From: Michael Flory
Sent: Monday, February 06, 2017 10:54 AM
To: Dusty Pilkington
Subject: RE: SX-17-00002 Shaffer

SHORELINE SUBSTANTIAL DEVELOPMENT PERMIT EXEMPTION

Rebuilding of Single Family Residence.

File No.
SX-17-00002

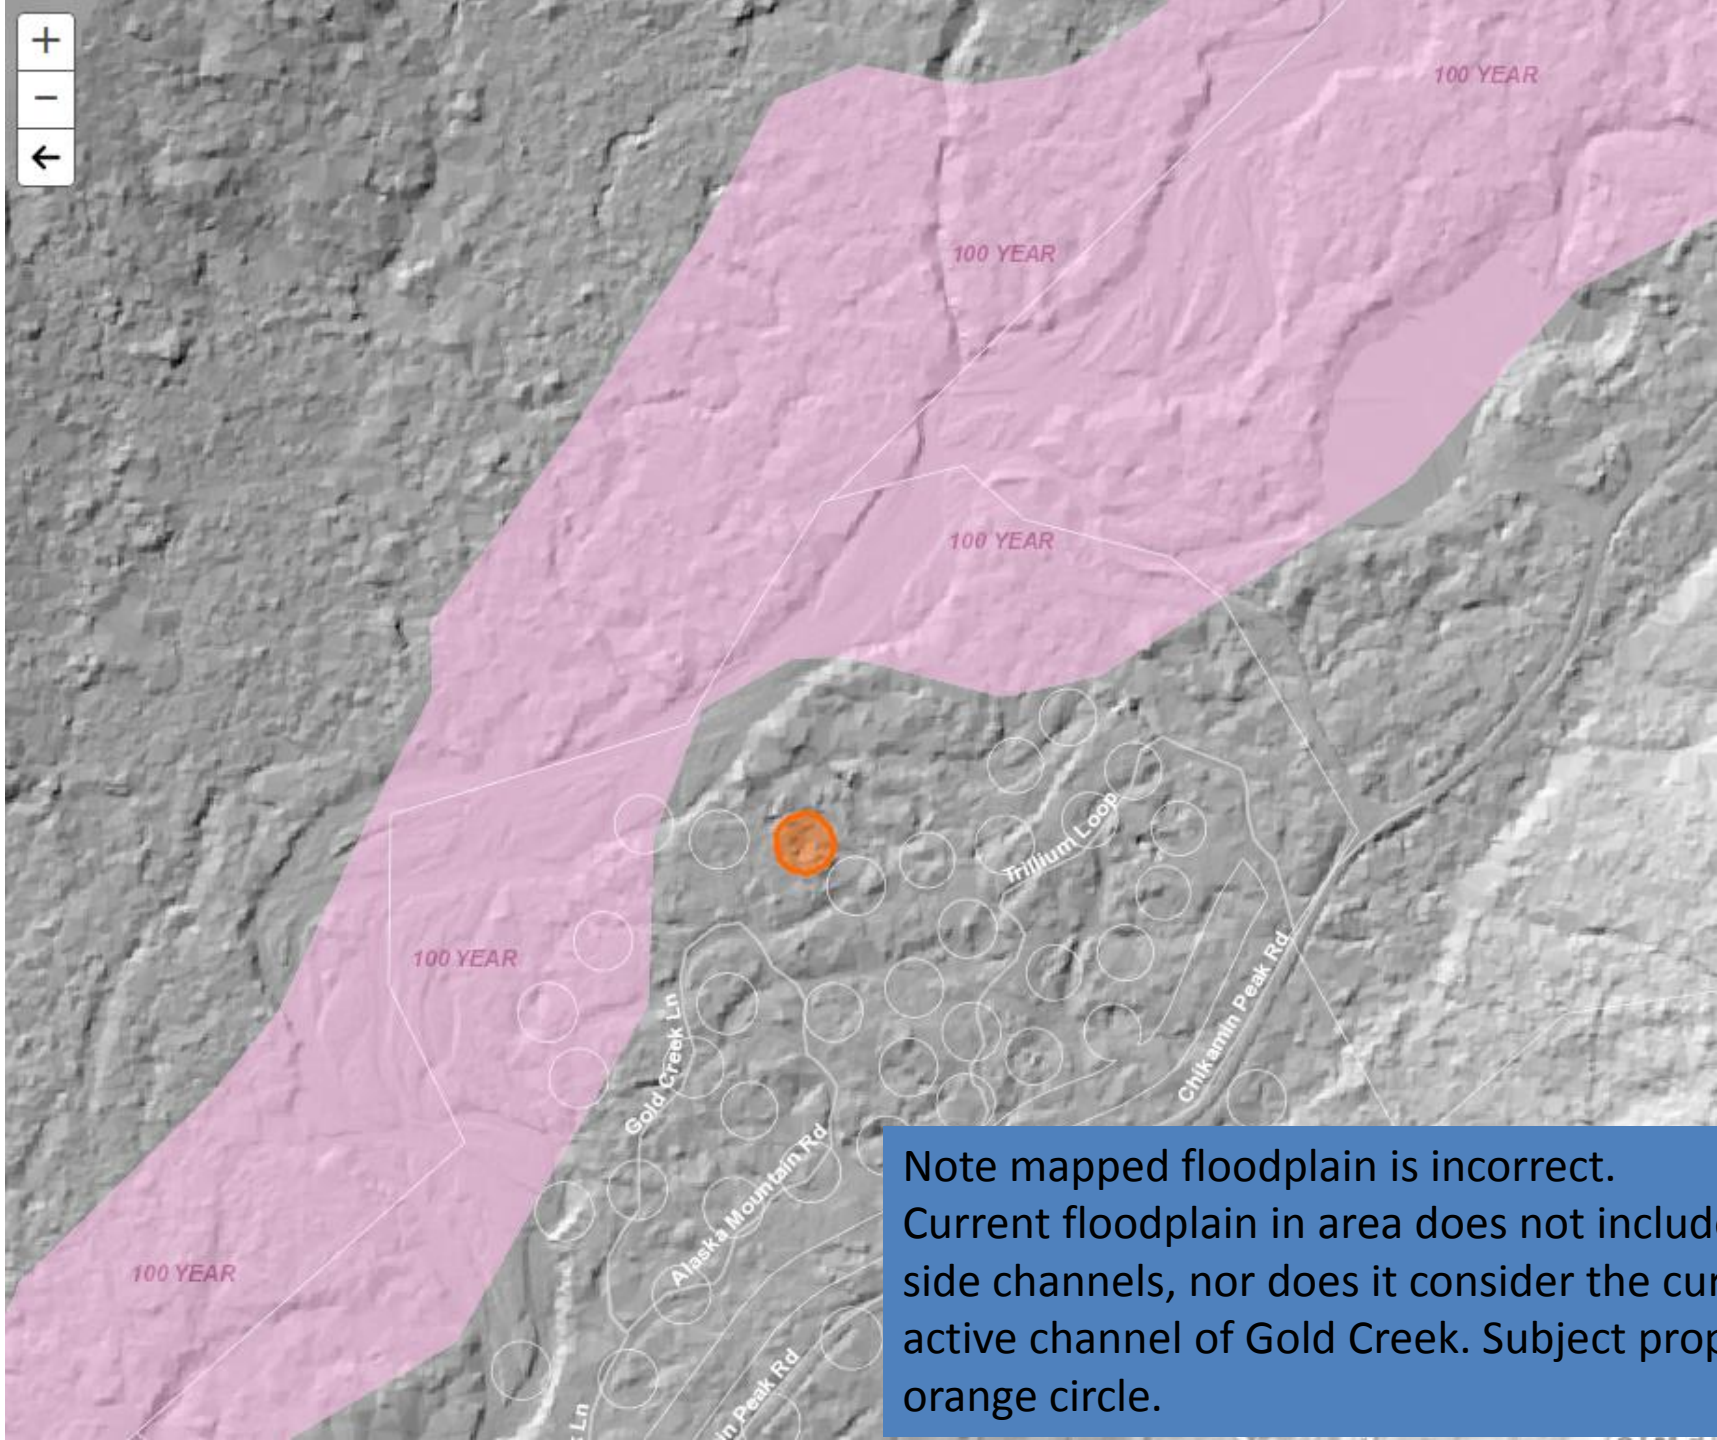
Side channels that could be reopened if berms are washed away

Note mapped floodplain is incorrect. Current floodplain in area does not include side channels, nor does it consider the current active channel of Gold Creek. Subject property is orange circle.

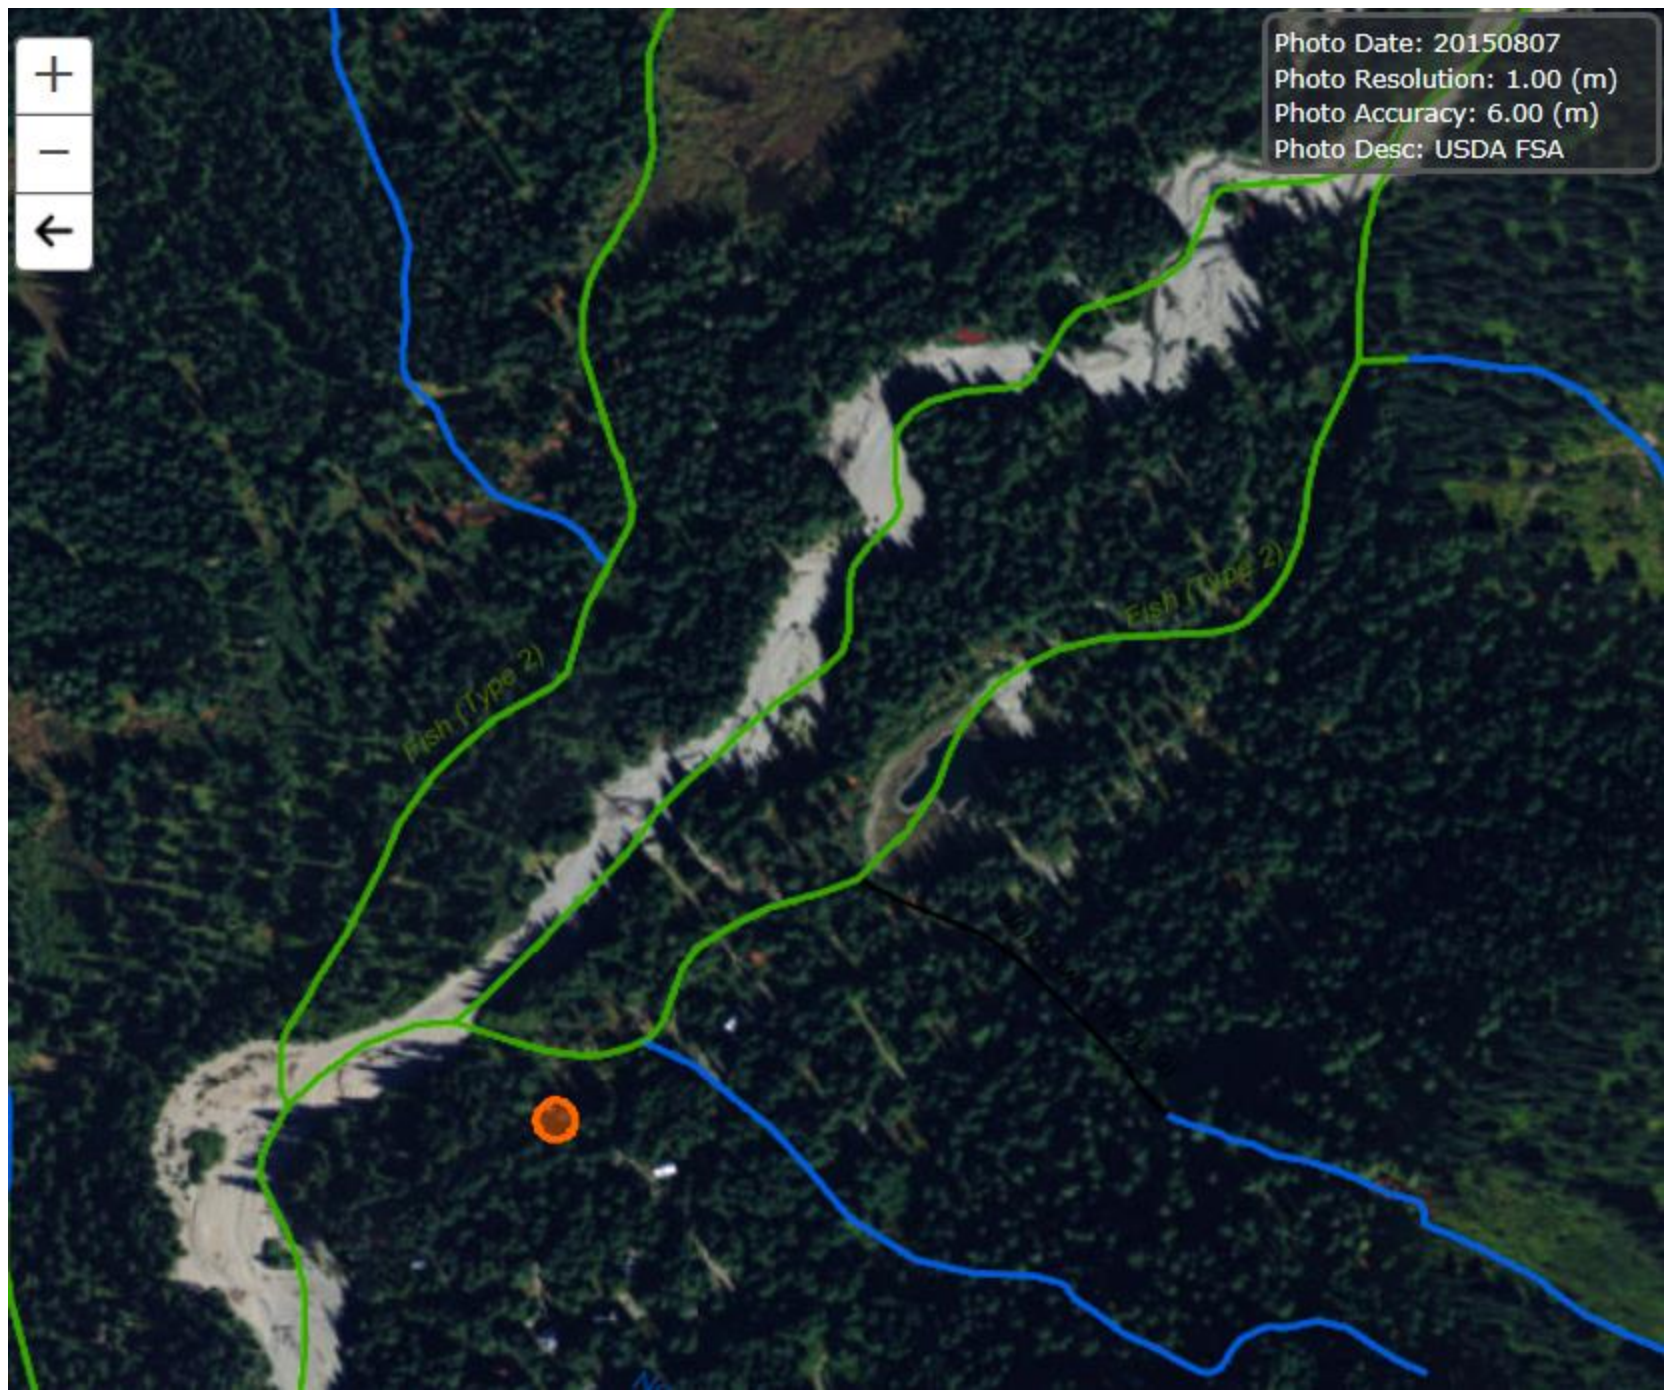
Current cabin site and associated side channel looking east
Picture taken immediately NW of cabin site looking back towards cabin

Dike, just south of Heli's Pond that currently diverts most of the water away from Cabins to the south. If this dike were to break, the cabin site would get annual spring flows.
